HAY CREEK VALLEY
MDDP / ~~FINAL~~ DRAINAGE REPORT

Preliminary Drainage
Report

Project No. 22.886.076

Please update to
PCD File SP-23-01

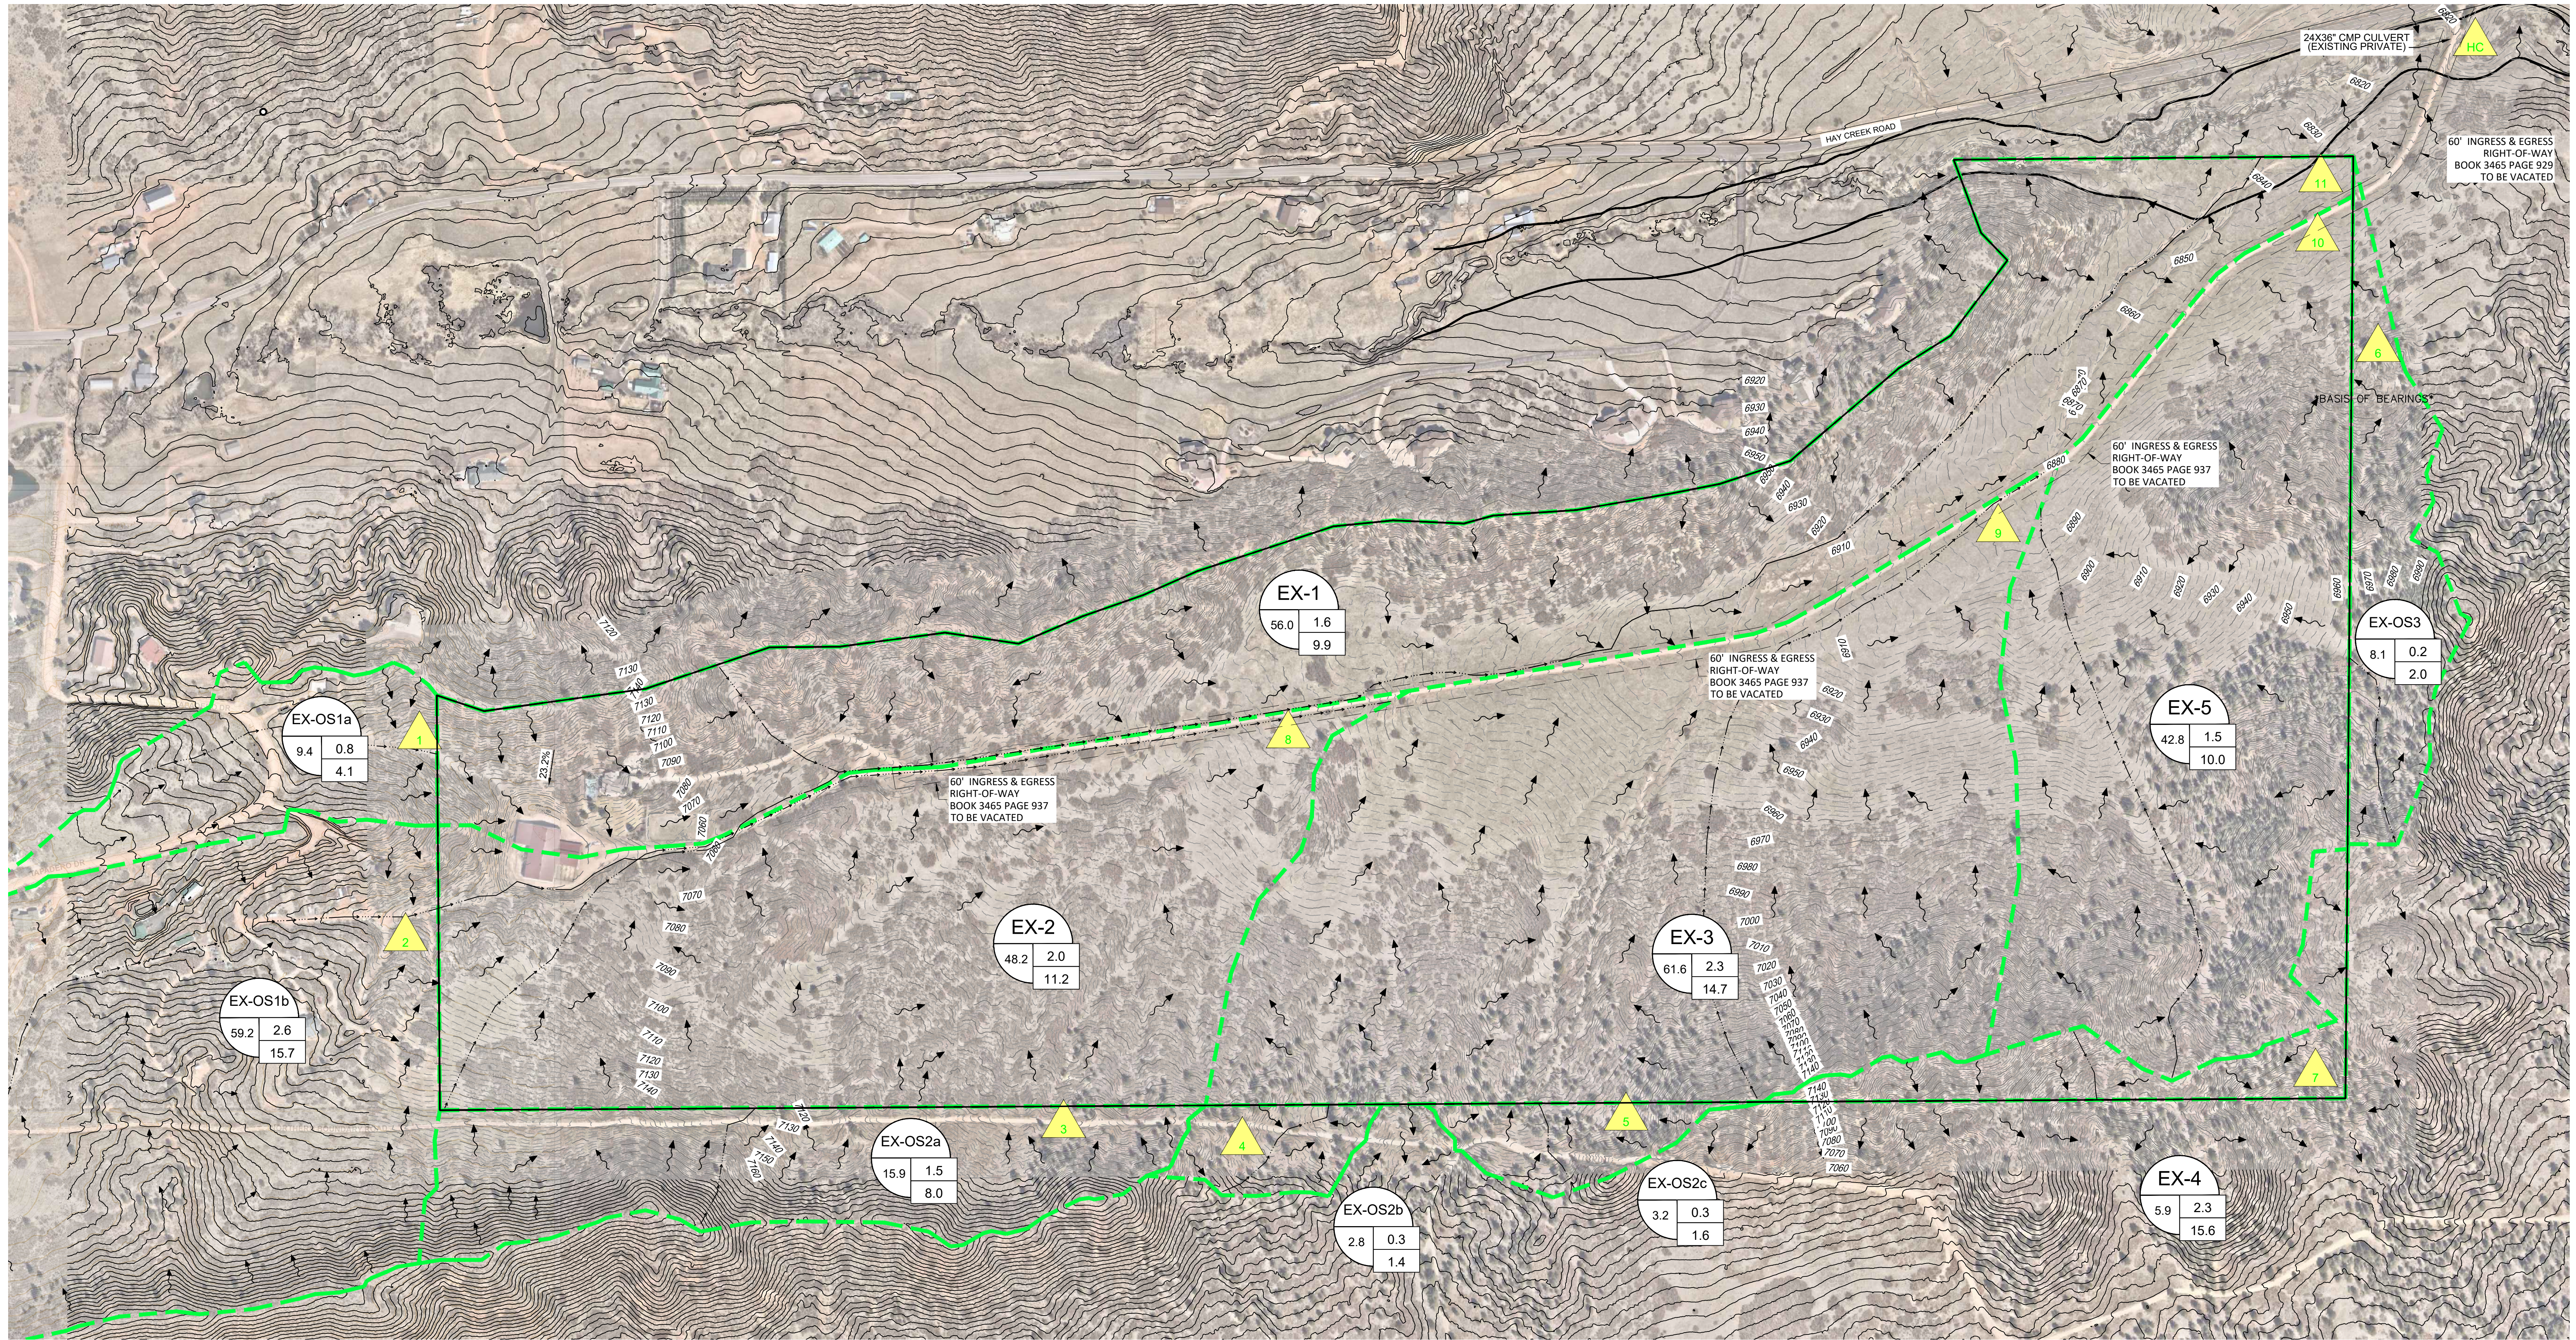
Provide Design point and analysis for the Hay Creek Road intersection to include existing/upgraded culvert analysis. Show on drainage maps.
